Matrix Design Group, Inc.  
2425 Research Parkway, Suite 300  
Colorado Springs, CO 80920  
O 719.575.0100  
F 719.575.0208  
matrixdesigngroup.com

December 3, 2025

**RE: Rolling Meadows Parkway/Prairie Song Drive Roundabout Configurations and Traffic Operations**

**EASTBOUND/WESTBOUND
VEHICLE TRACKING PATH
(WB-67)**

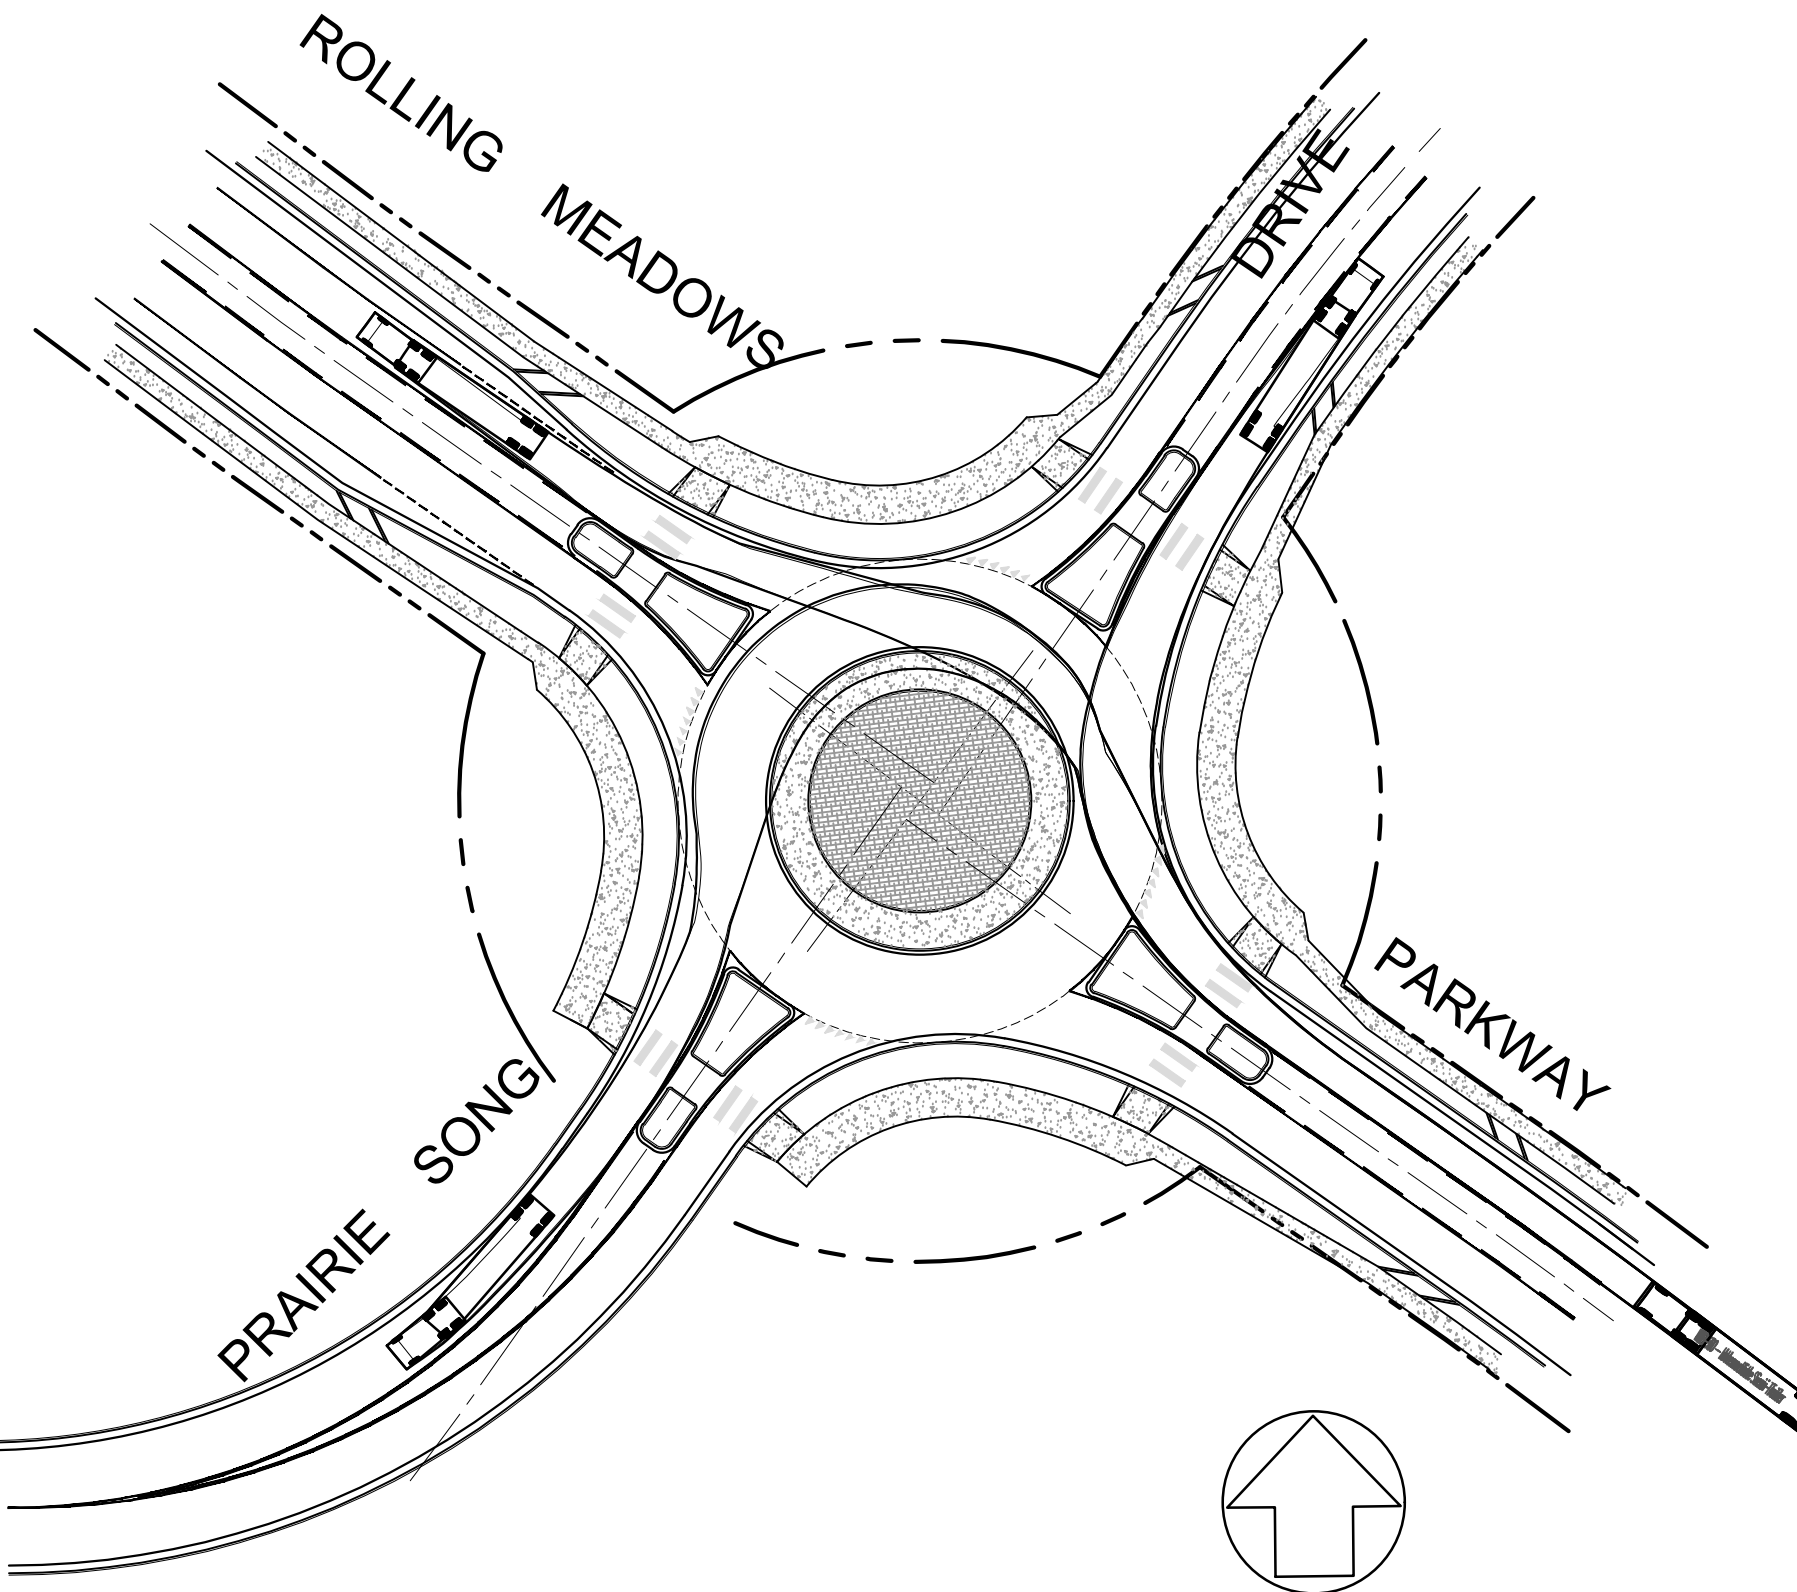
Provide WB-67 tracking also

A WB-67 has been added for reference and shown in eastbound/westbound movements. Per section 3.3 of the NCHRP, the design vehicle for an urban roundabout shall be a bus or single-unit truck (WB-50 used). Although the design or control vehicle for an urban roundabout is not a WB-67, and no commercial parcels are proposed passed the roundabout, we have shown the WB-67 going eastbound/westbound for reference.

VEHICLE TRACKING PATH

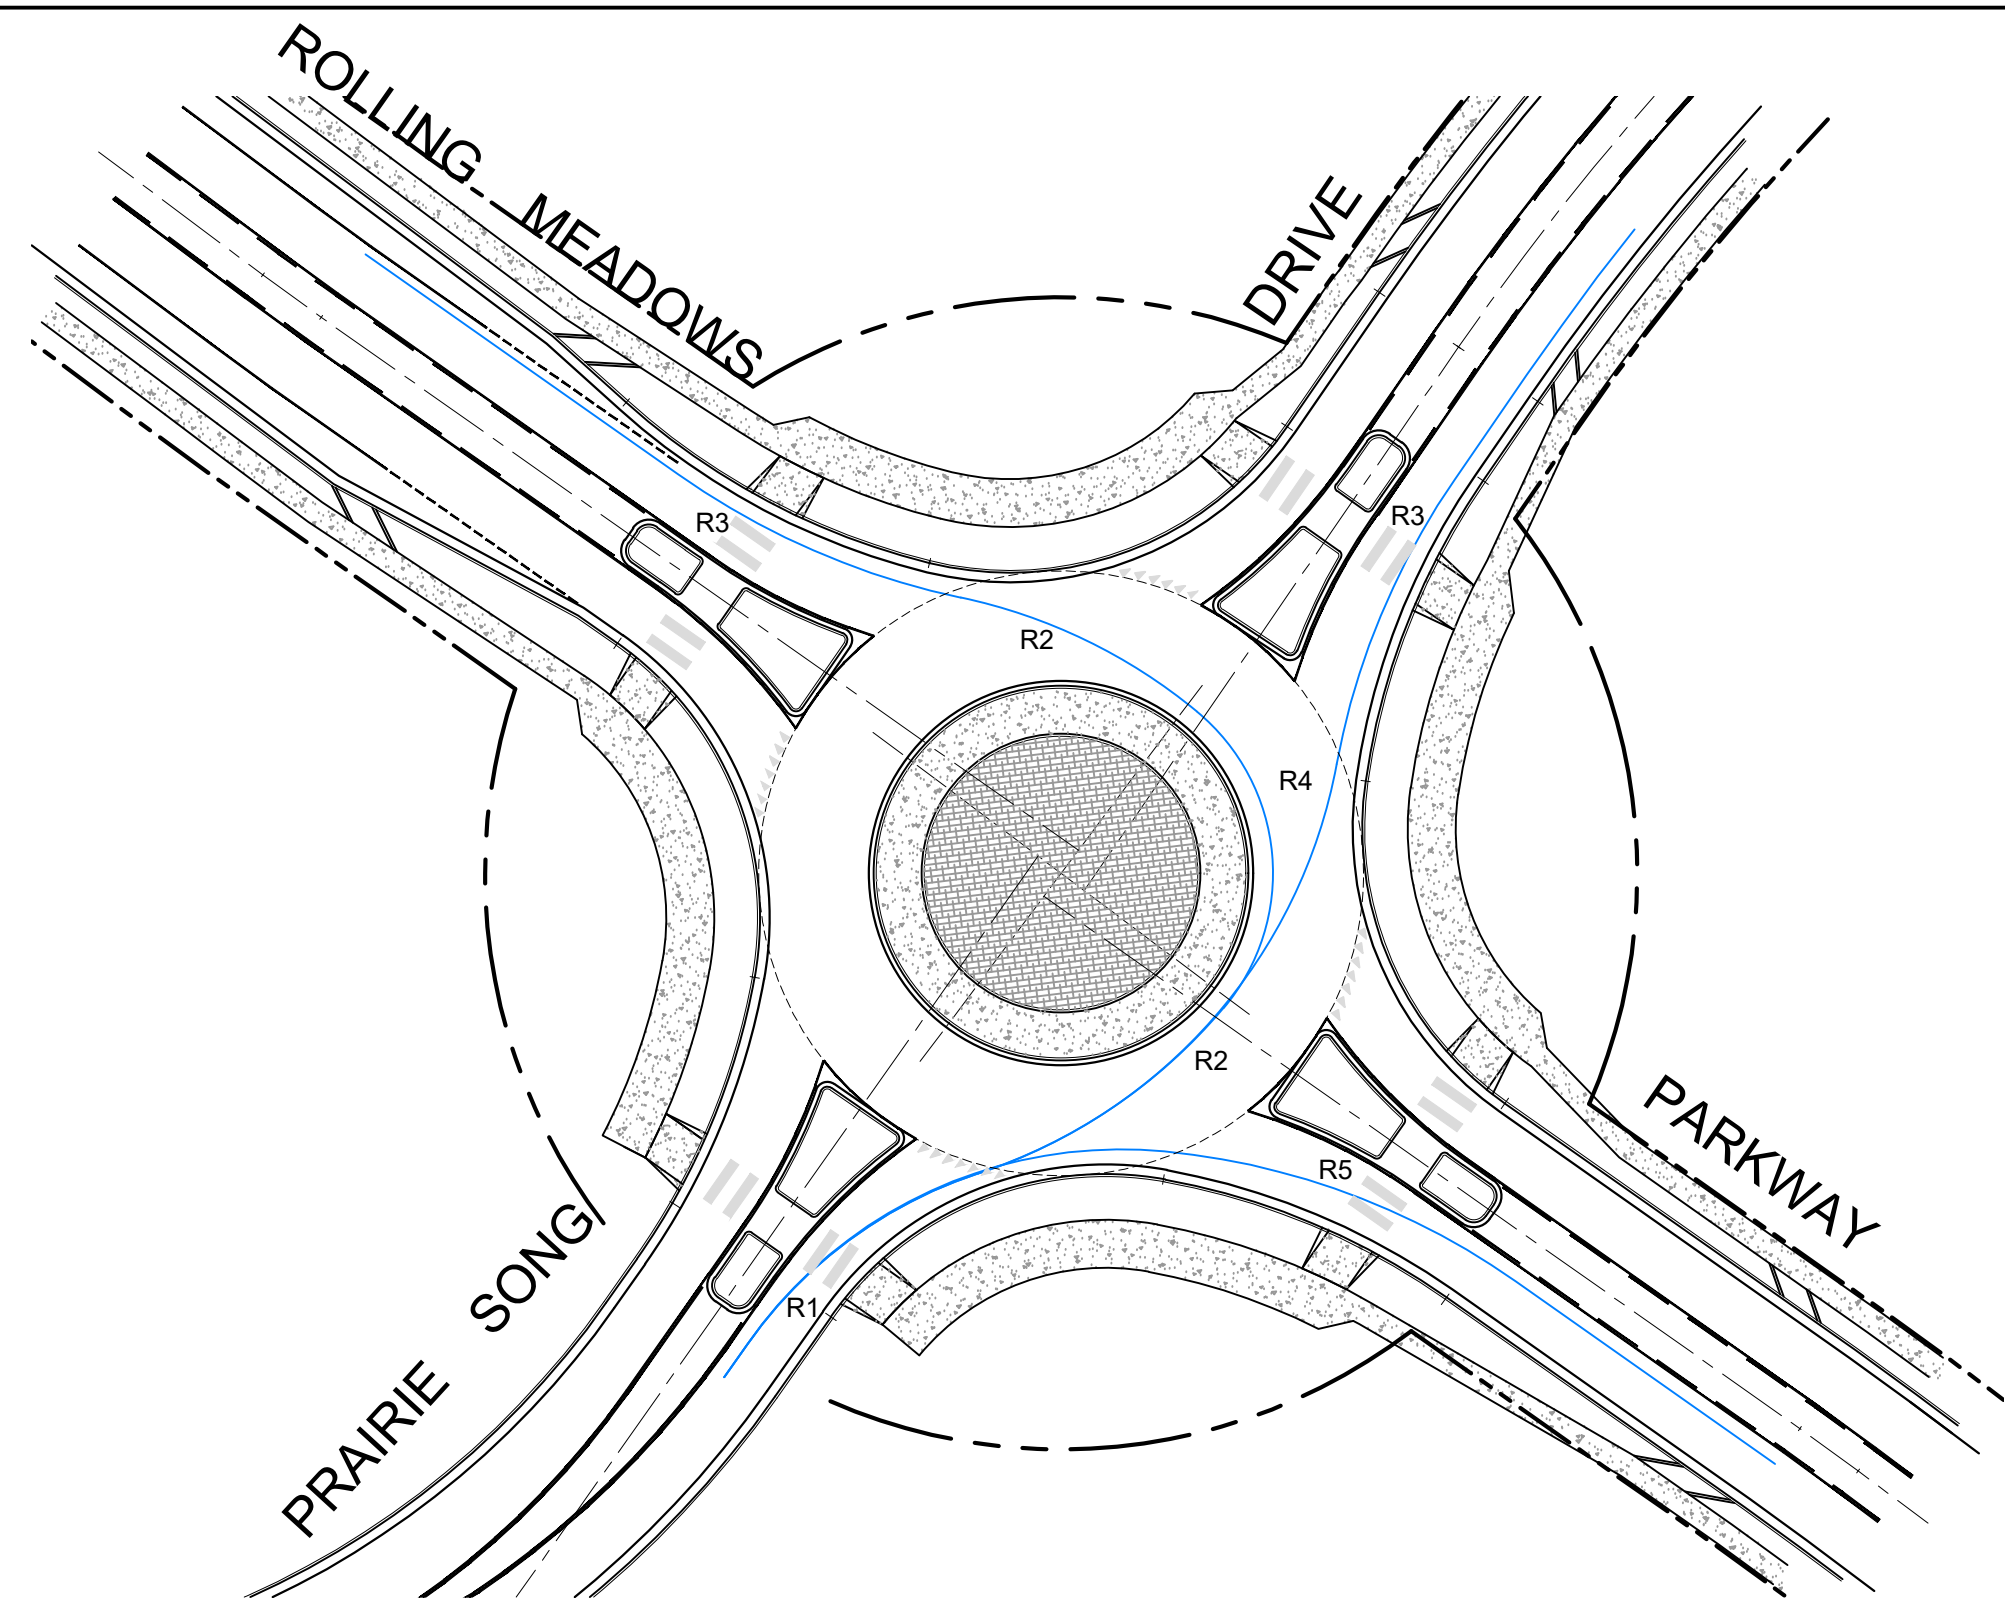
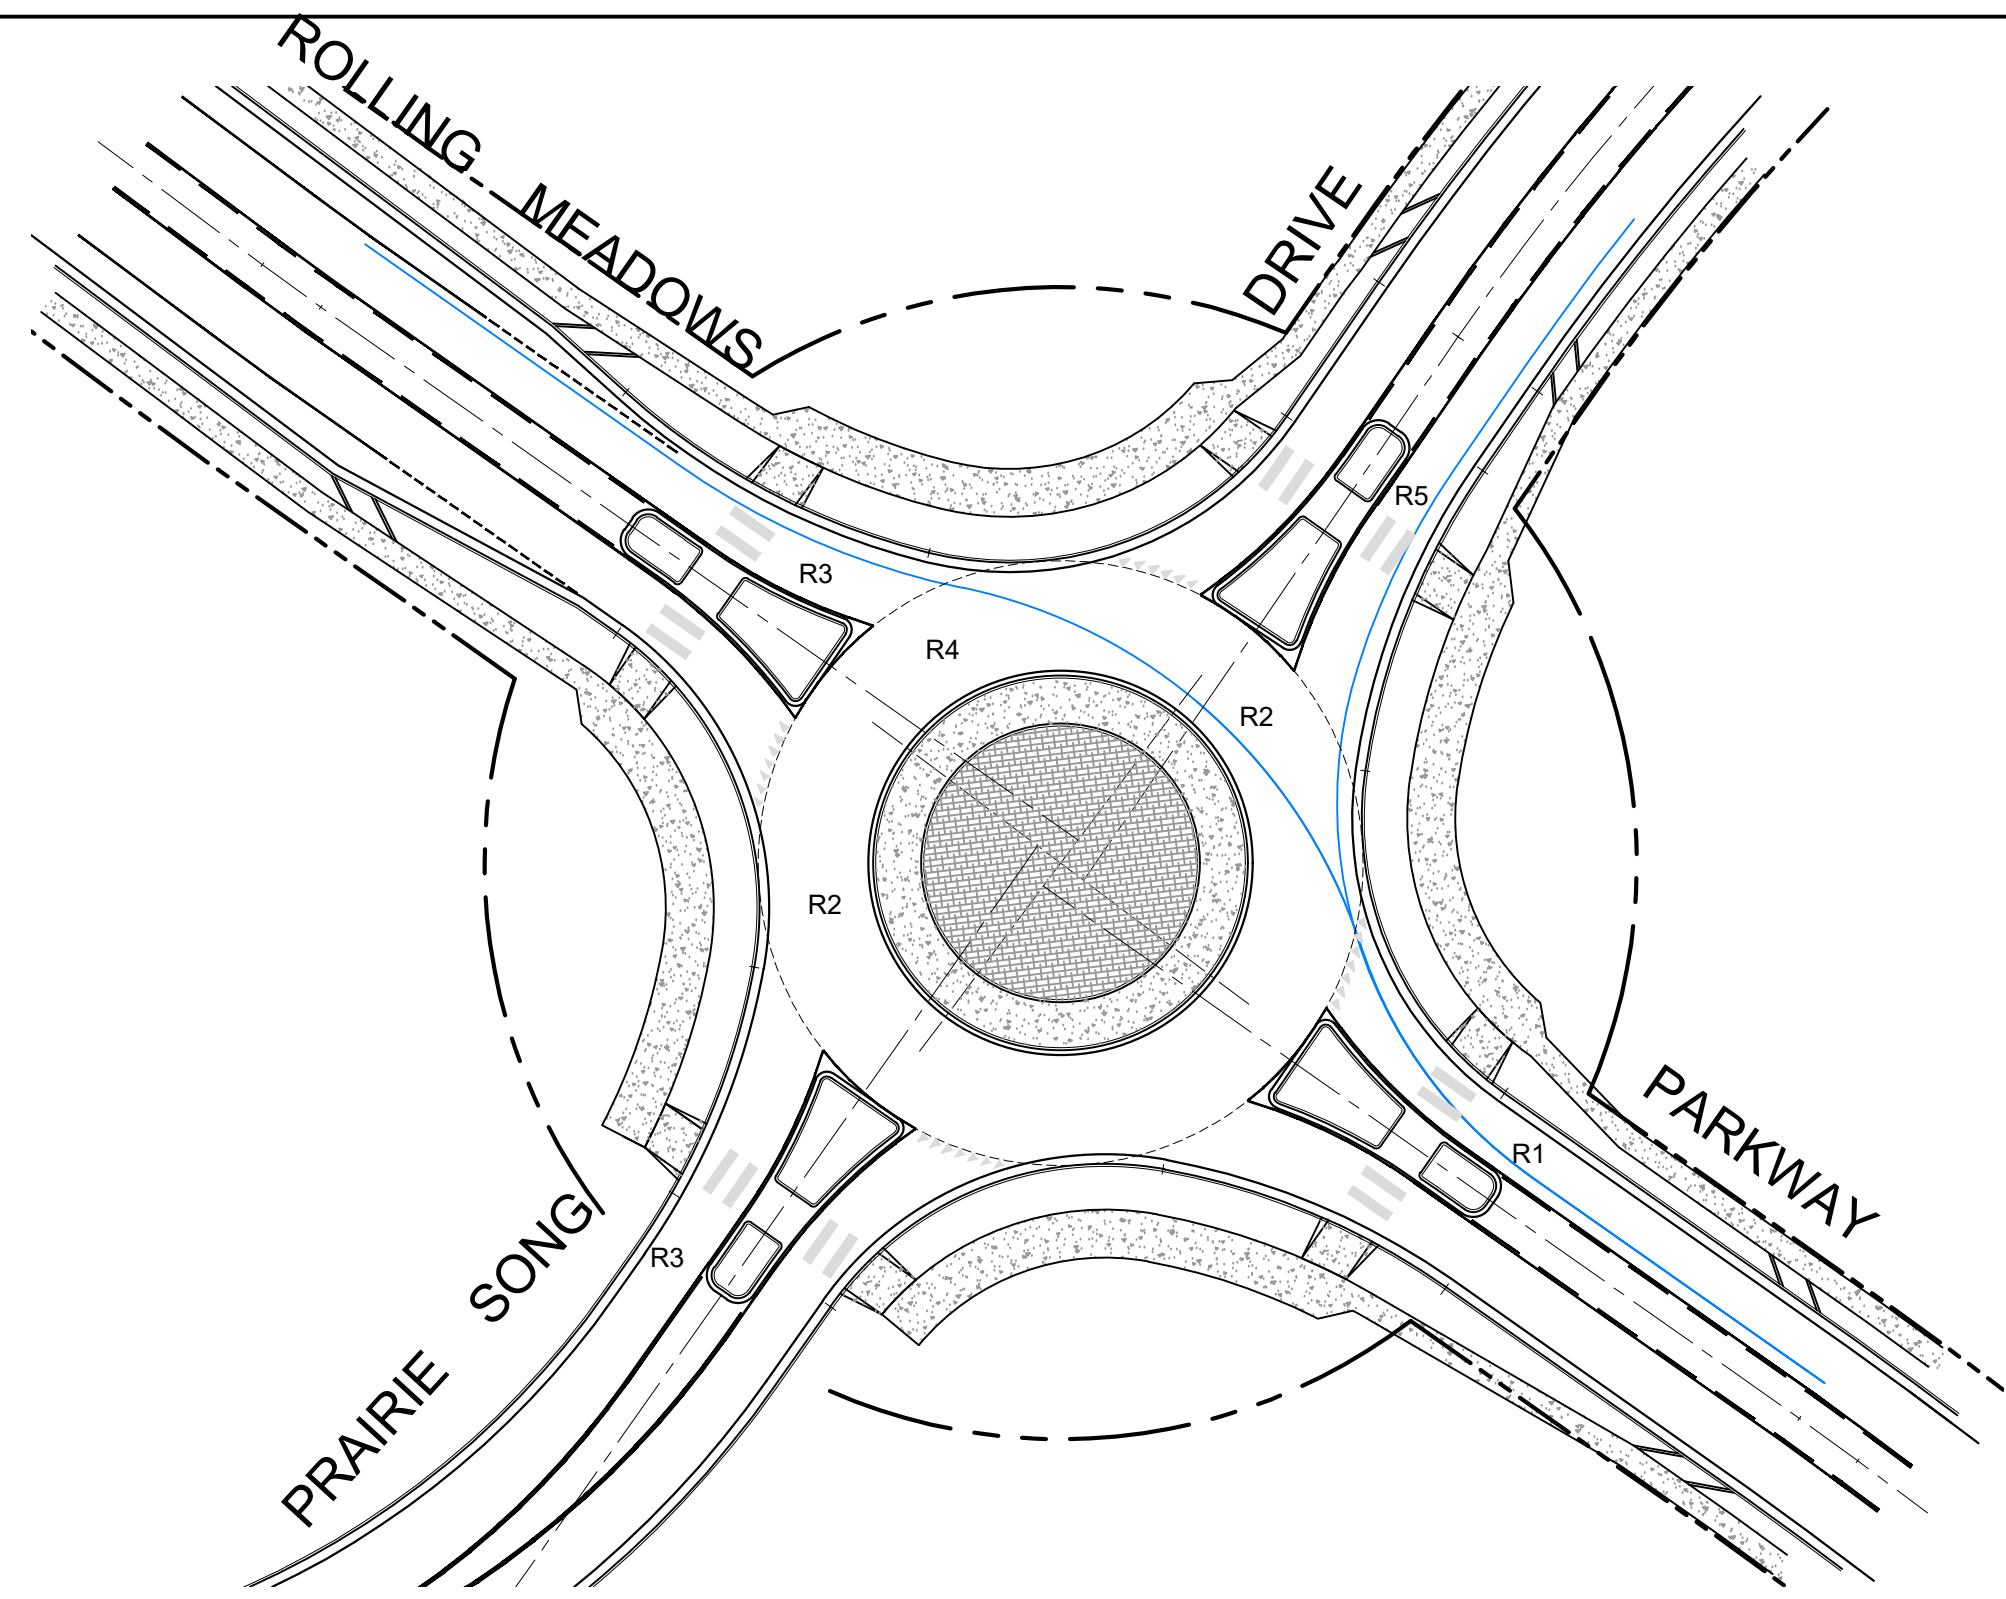
El Paso County now follows NCHRP 1043 for roundabout design and design checks (Appendix A-1 of the NCHRP document). Please ensure all design checks shown in the NCHRP document are met.

noted, NCHRP 1043 used for updates
